**Our Case Number: ABP-314724-22**

**Re: Railway (Metrolink - Estuary to Charlemont via Dublin Airport) Order [2022]**  
Metrolink. Estuary through Swords, Dublin Airport, Ballymun, Glasnevin and City Centre to Charlemont, Co. Dublin

# NDA submission for Metrolink Railway order

Drawing Title	ESTUARY PARK AND RIDE ARCHITECTURAL GENERAL FIRST FLOOR PLAN		Drawing Status	S0
Drawing N°	ML1-JAI-SRD-ROUT_XX-DR-Y-06003	Plan Drawing N°	ML-MS 301 B-C3	
Scales Original Size A1	1 : 400	Sheet	1	of 1

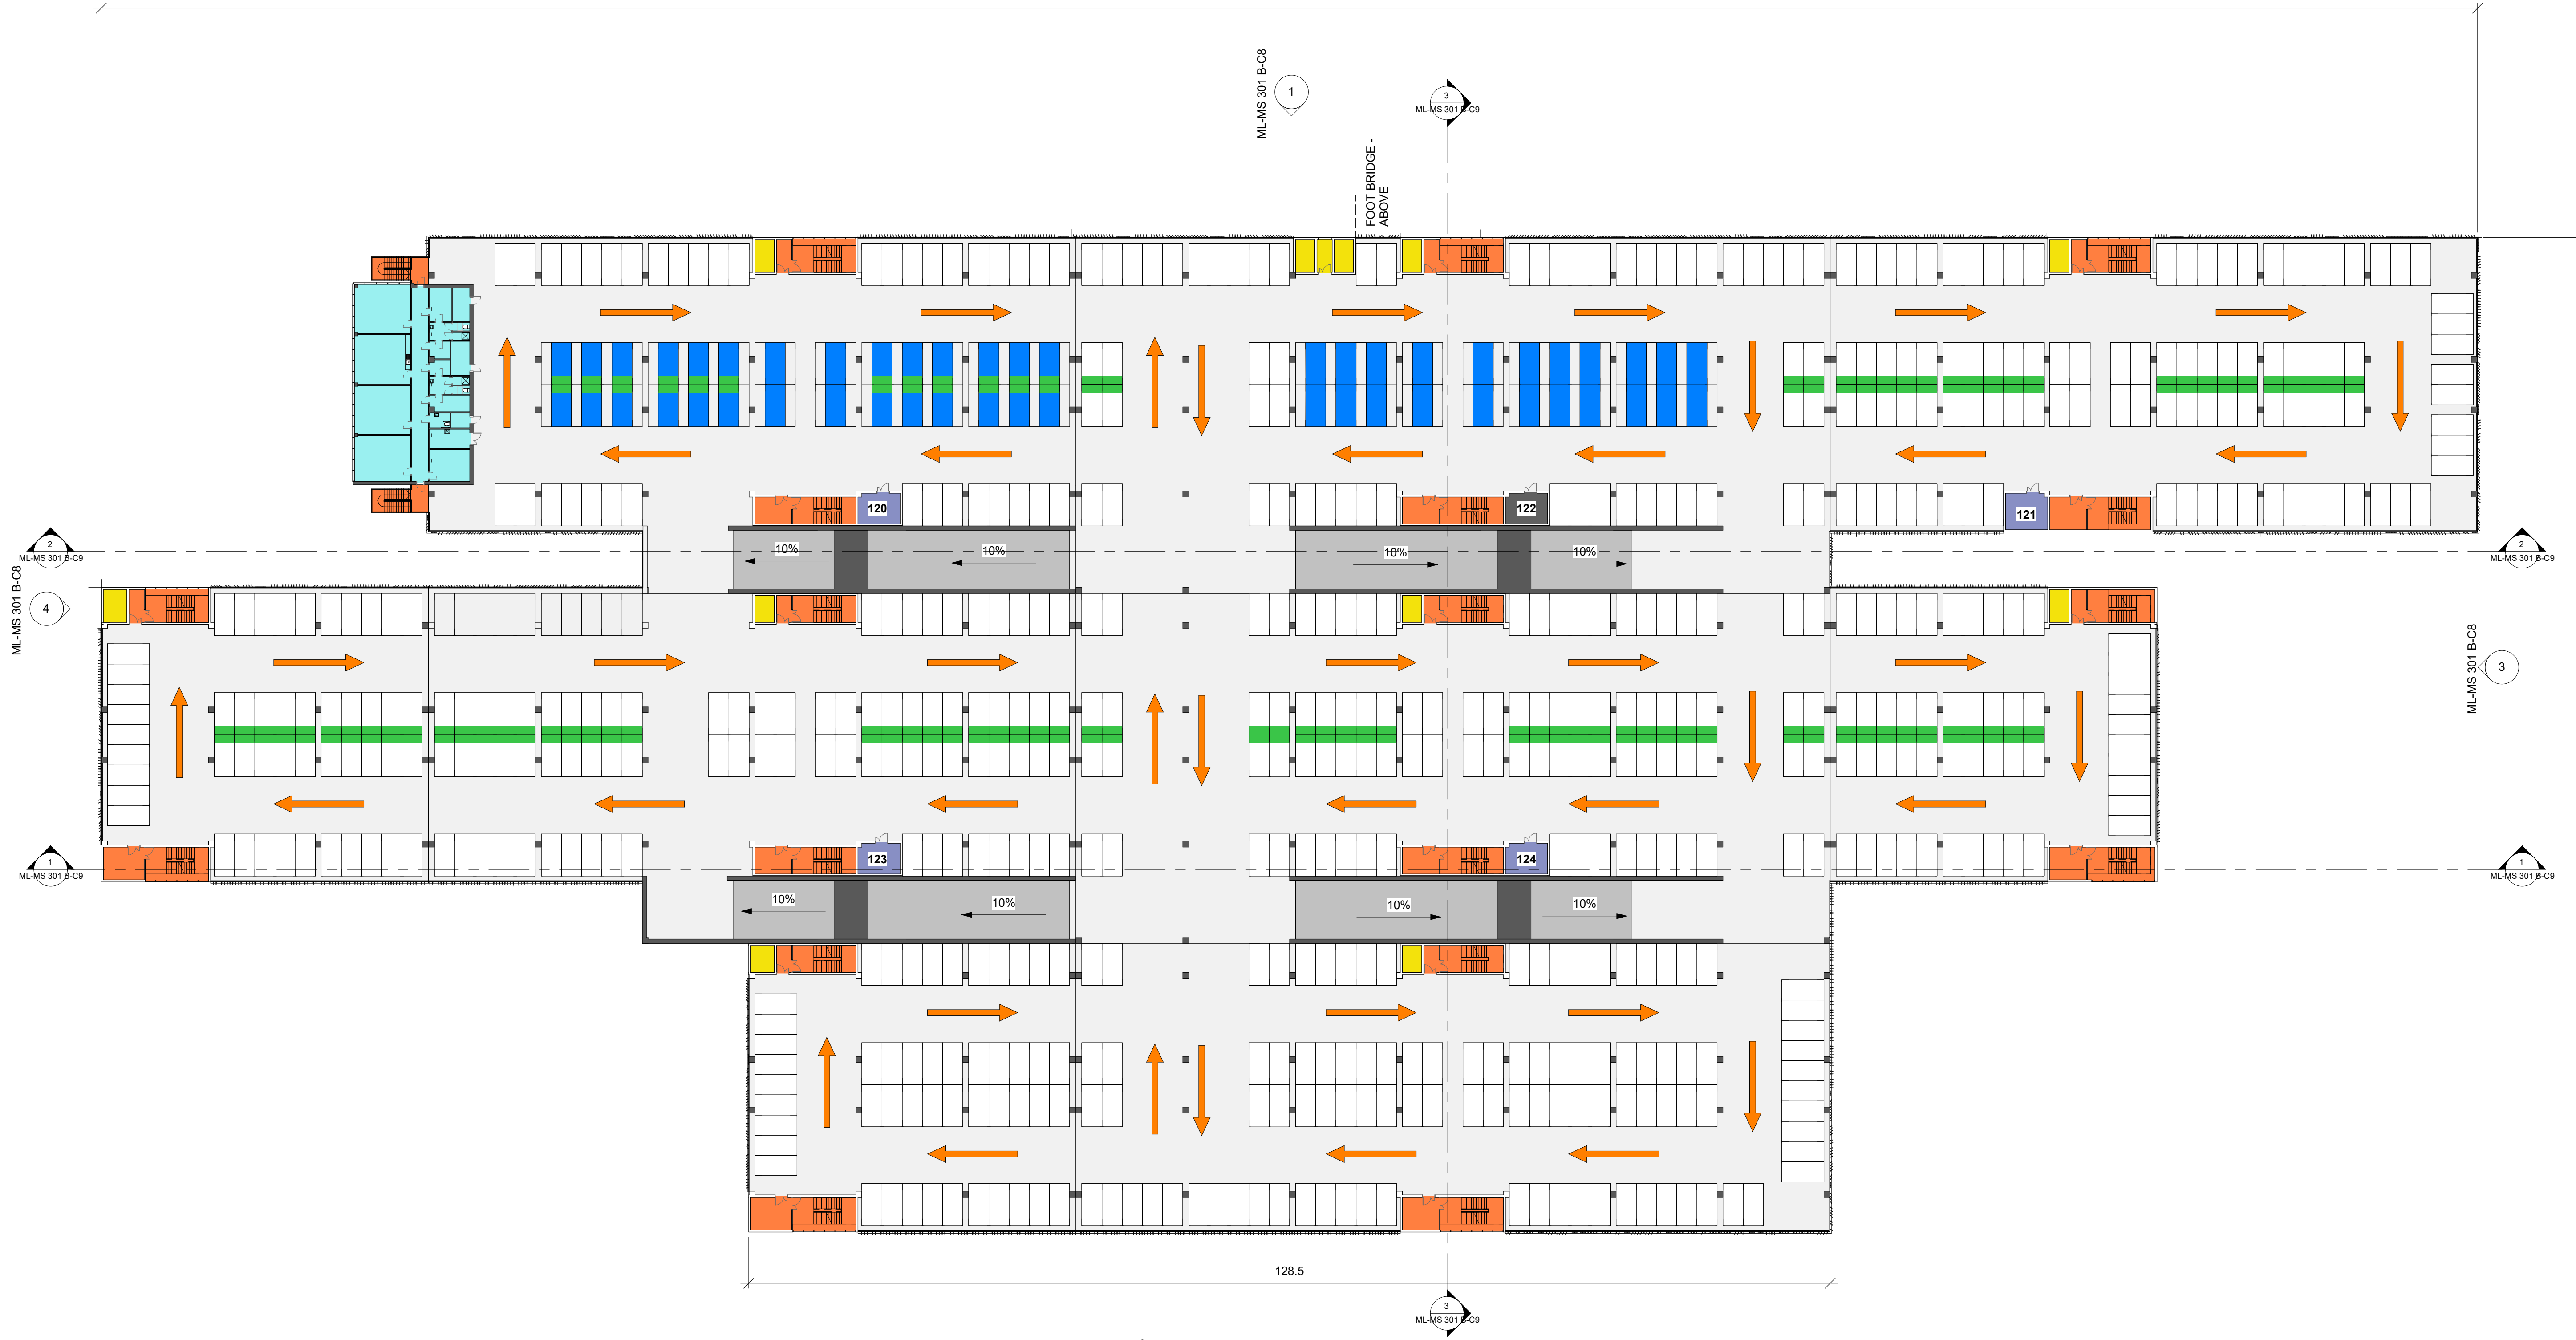
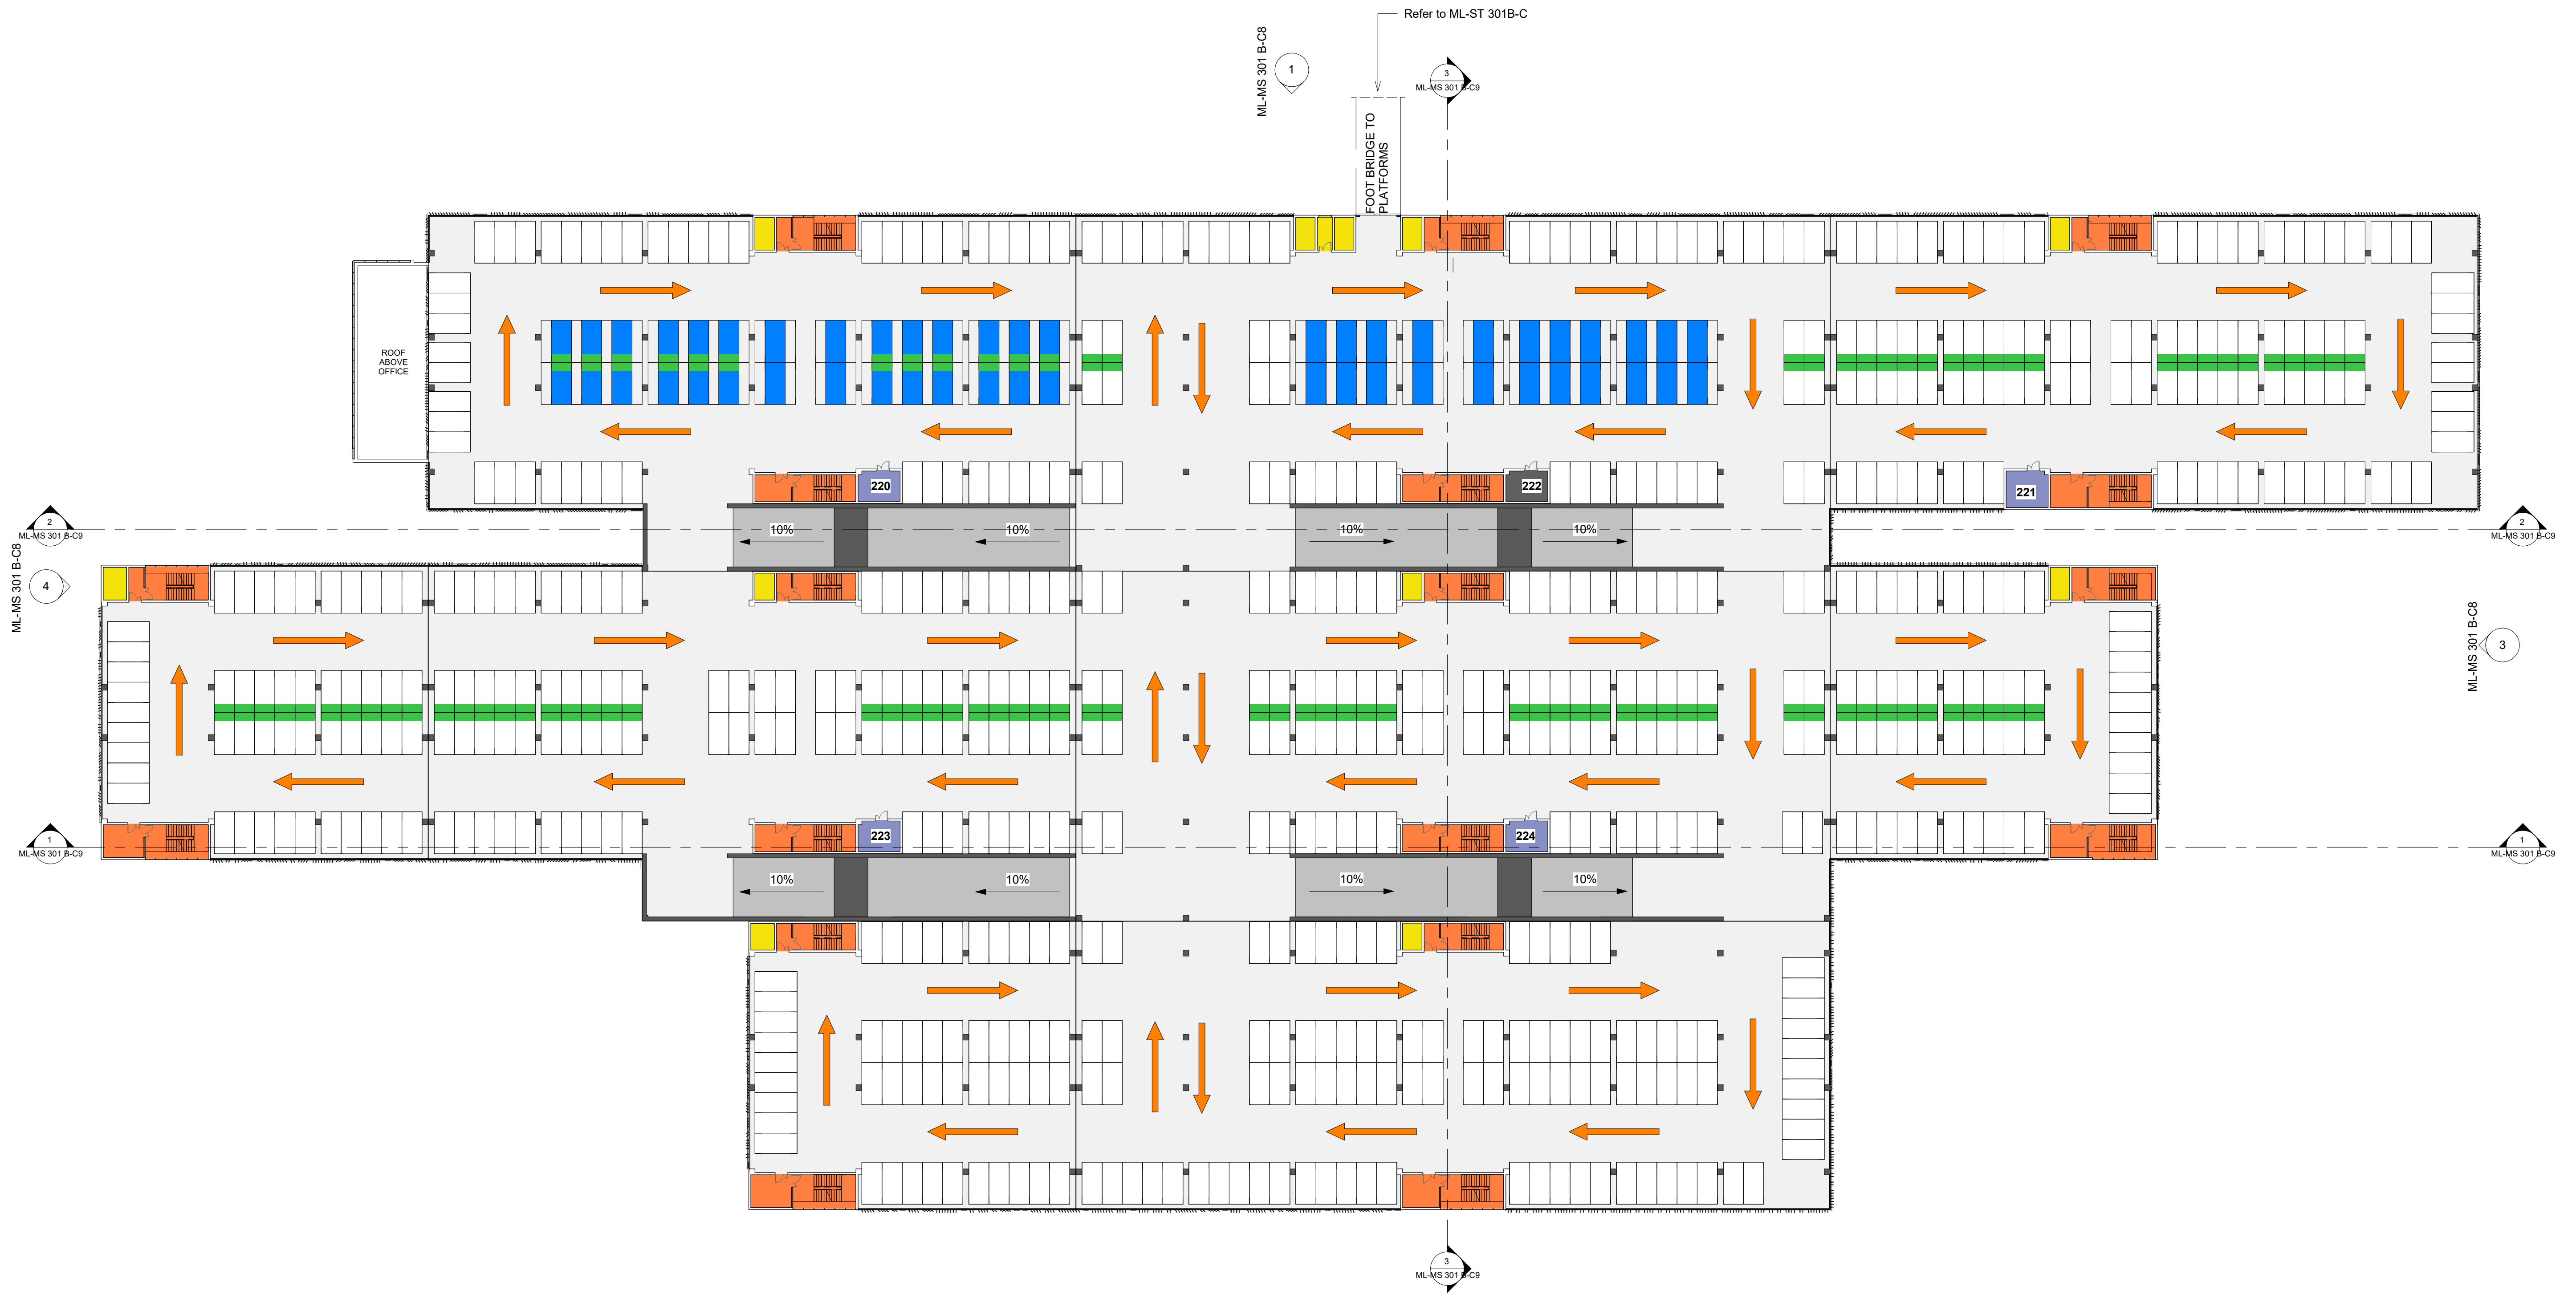
The NDA would also like further detail on how proposed pedestrian underpasses as detailed in the plans for Estuary station and the associated park and ride building will be accessible to wheelchair users for example, as the designs only seem to mention access via stairs and the proposed lifts detailed do not seem to grant access to the underpass level.
